February 2, 2021

Planning Application for Non-Material Amendment to permission (appeal ref) W/4000394 (application ref Y/103/18/PL) for Single Chapel Crematorium with car parking, landscape works, surface water drainage features and associated highway improvements

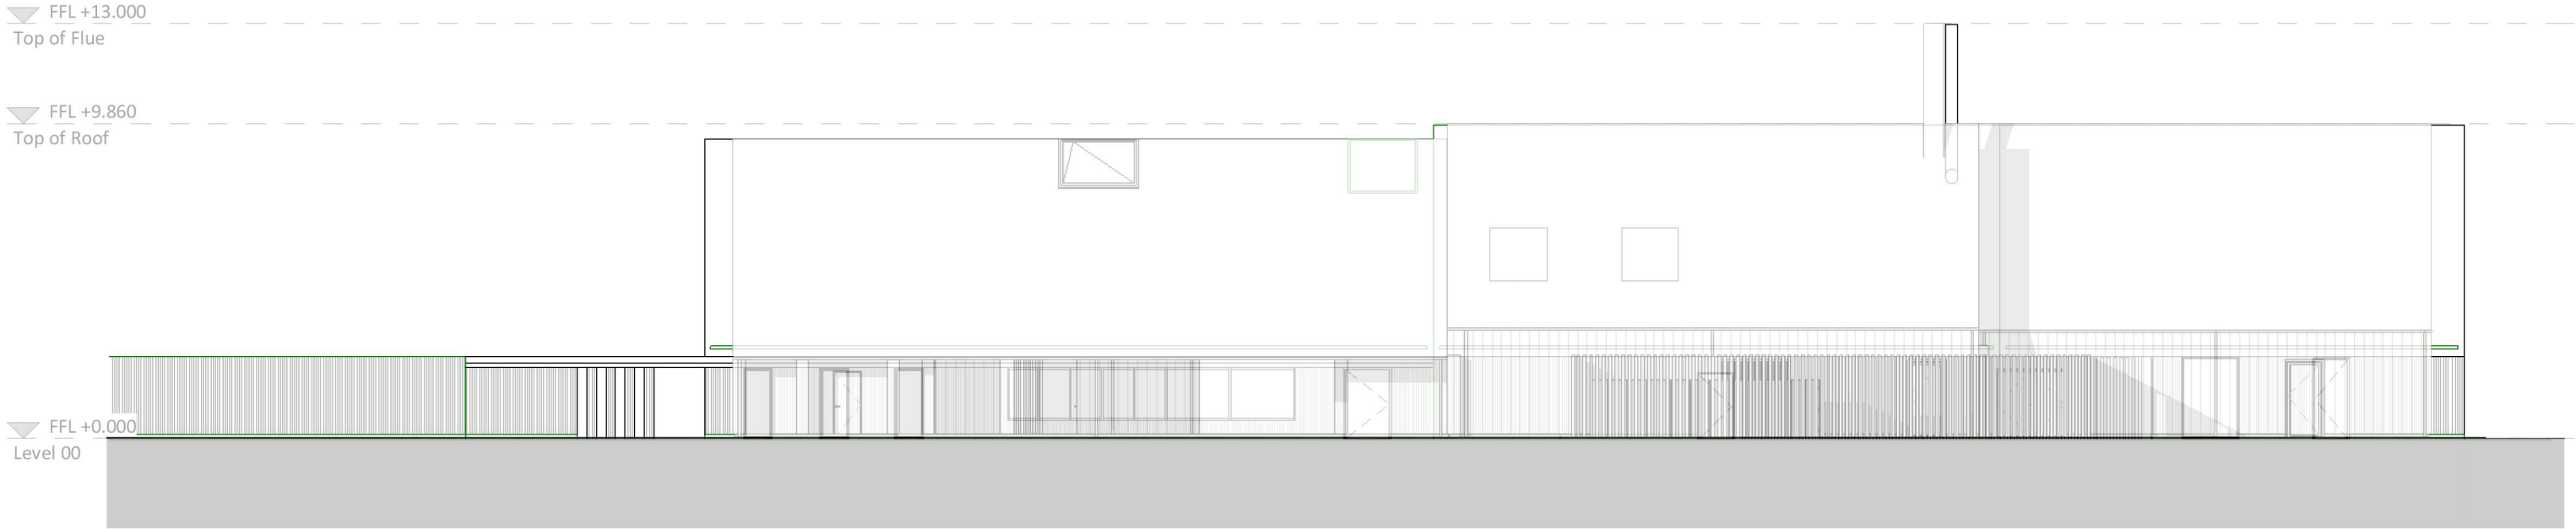
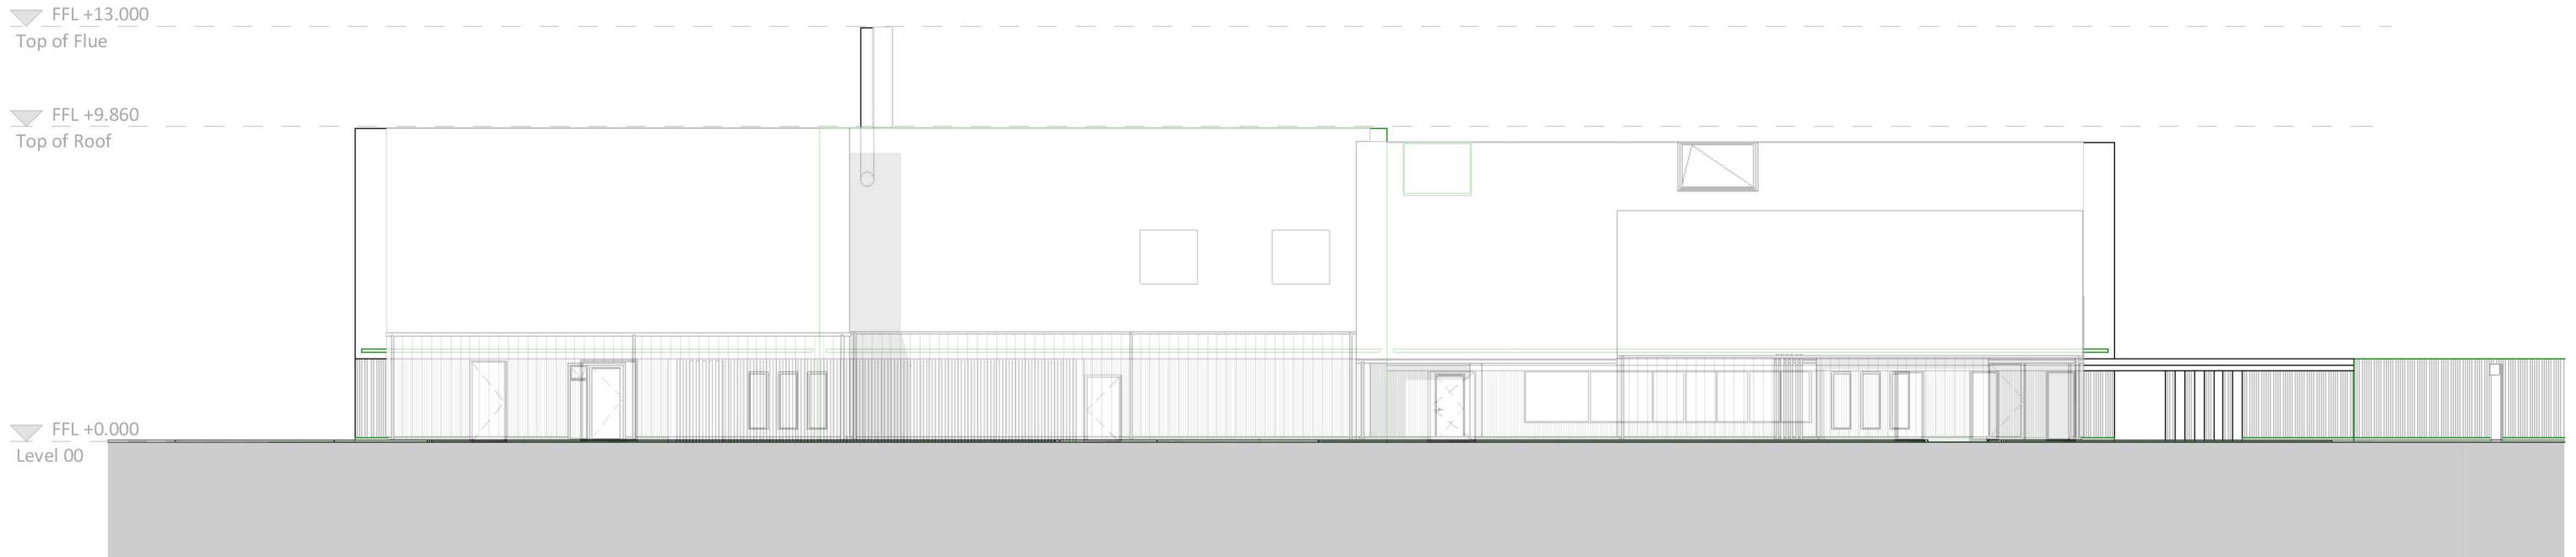
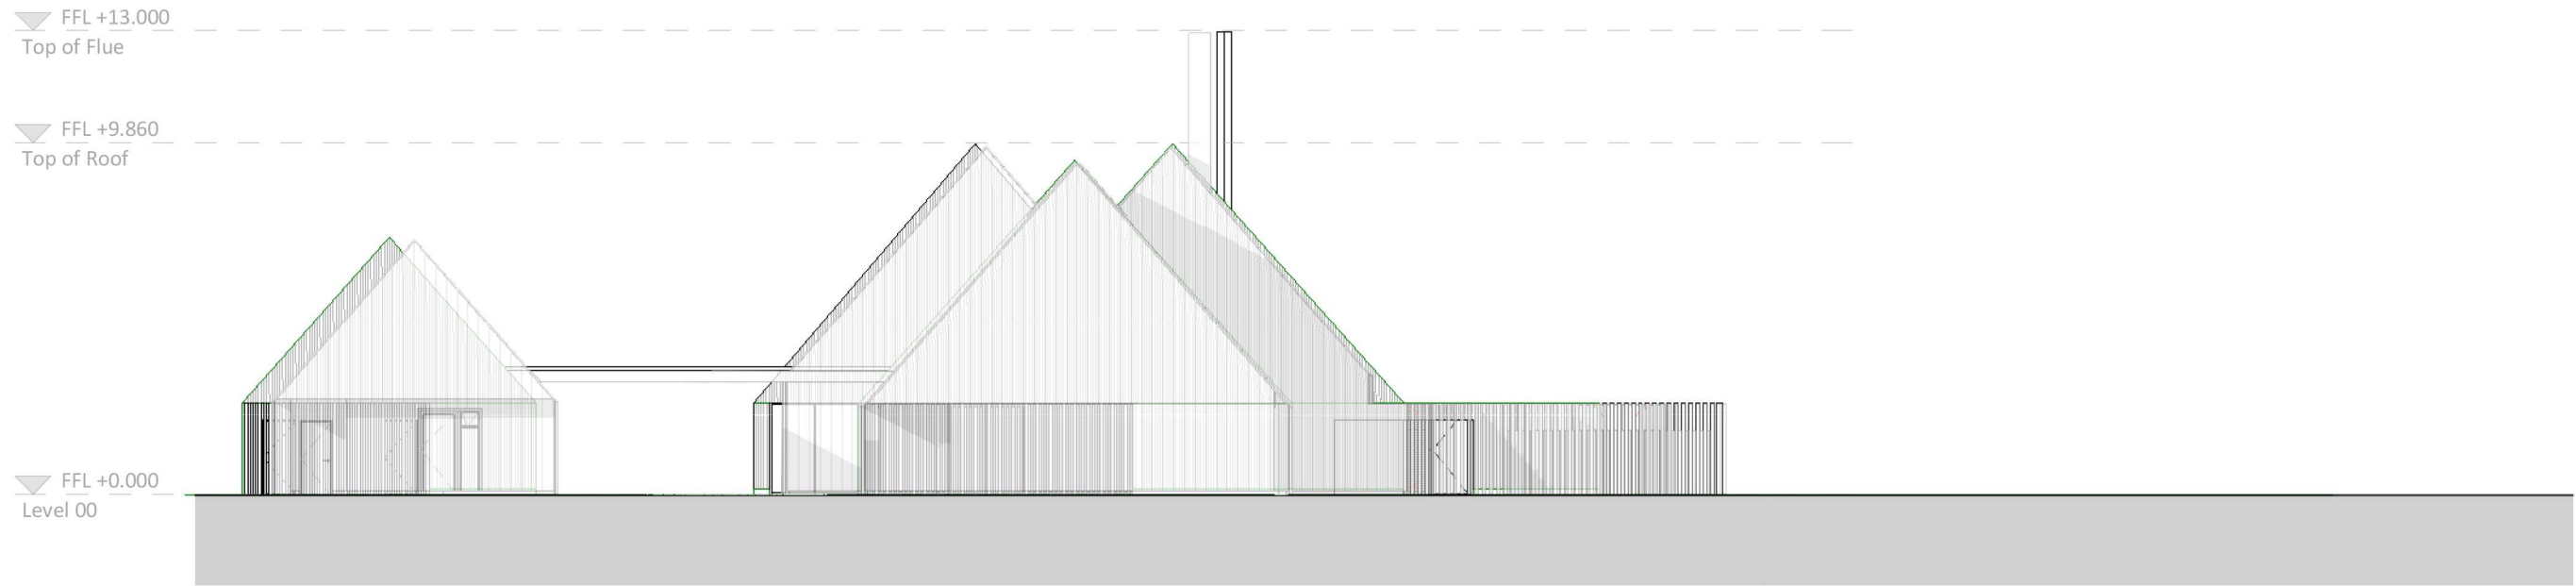
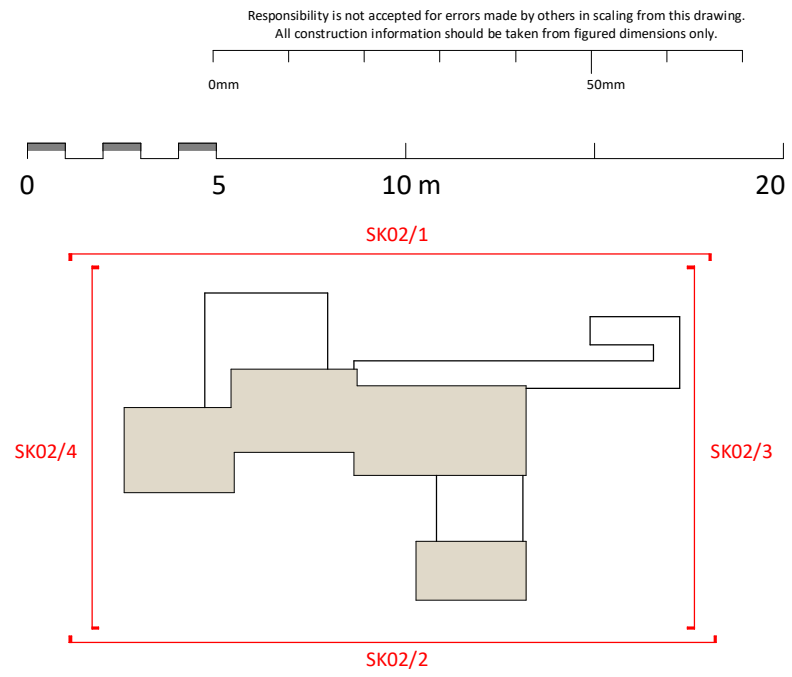
- There is no change to the original planning permission in terms of the description or intensity of use
- The application red line boundary remains unaltered
- There is no change to consideration against planning policy
- There is no potential overlooking from any of the windows from the proposal
- The planning obligation in the s106 remains unaffected by these proposals
- The changes do not materially alter the appearance of the building (as you can see in the comparison elevations and visualisation)

- There would be no increase in height
- There would be no increase in width or length
- The floorspace overall reduces from the approved area of 629.81sqm to 580.77sqm (a reduction of 49.04 sqm)
- The maximum the building moves from the current position is 950 mm, so always less than the 1 m limit.
- We do not believe that this change would warrant consultation with any neighbour or statutory body

PROJECT - ORIGINATOR - VOLUME - LEVEL - TYPE - ROLE - CLASS - NUMBER STATUS_REVISION
154380-STL-DR-A-SK01

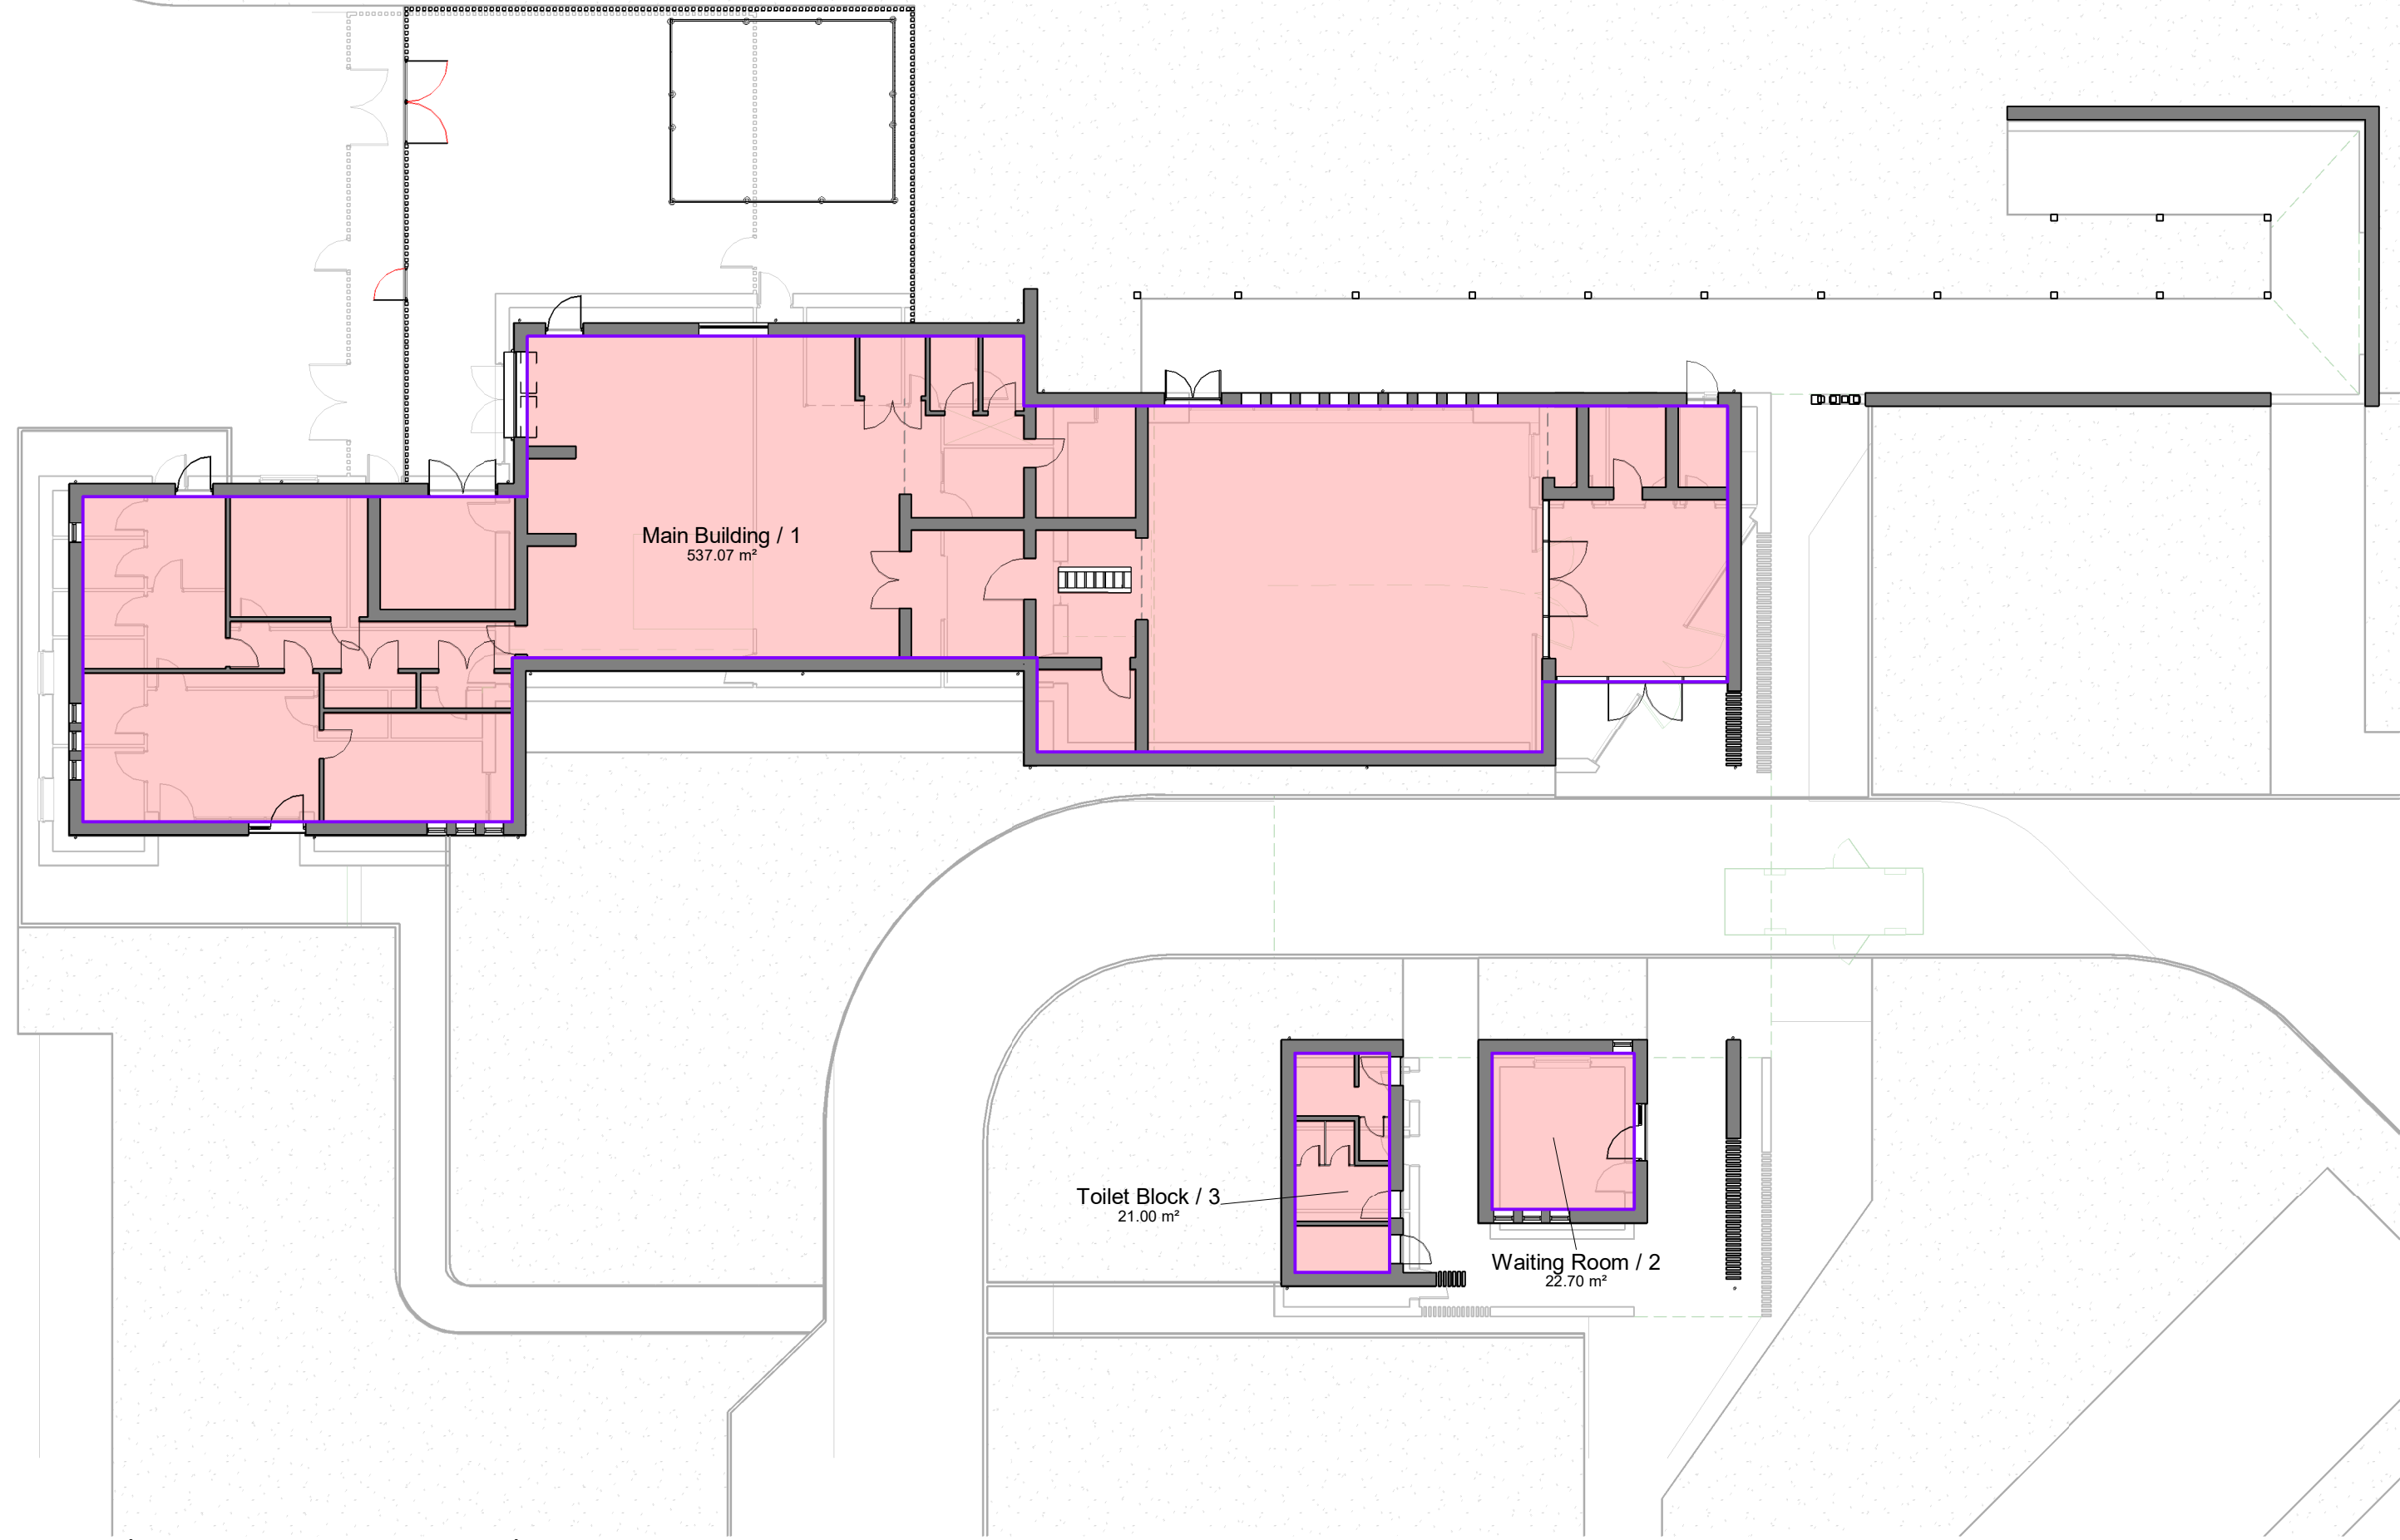
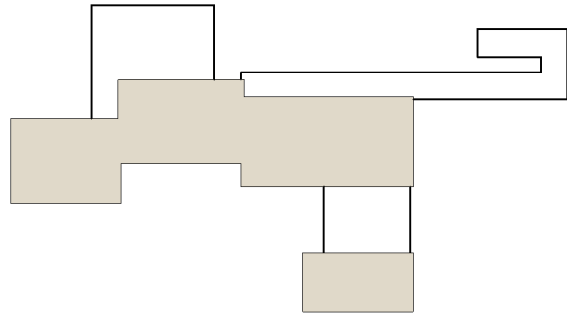
We have considered the advice regarding NMA criteria and as confirmed by your email of 4 January 2021 believe these are non-material amendments. This letter supports the application for the proposed amendments that the operators Westerleigh are seeking in their proposal and are submitted formally through the planning portal. The package of drawing includes useful overlays to compare the approved and proposed schemes, in particular drawing 154380-STL-DR-A-SK01, which has a site and building comparison overlay.
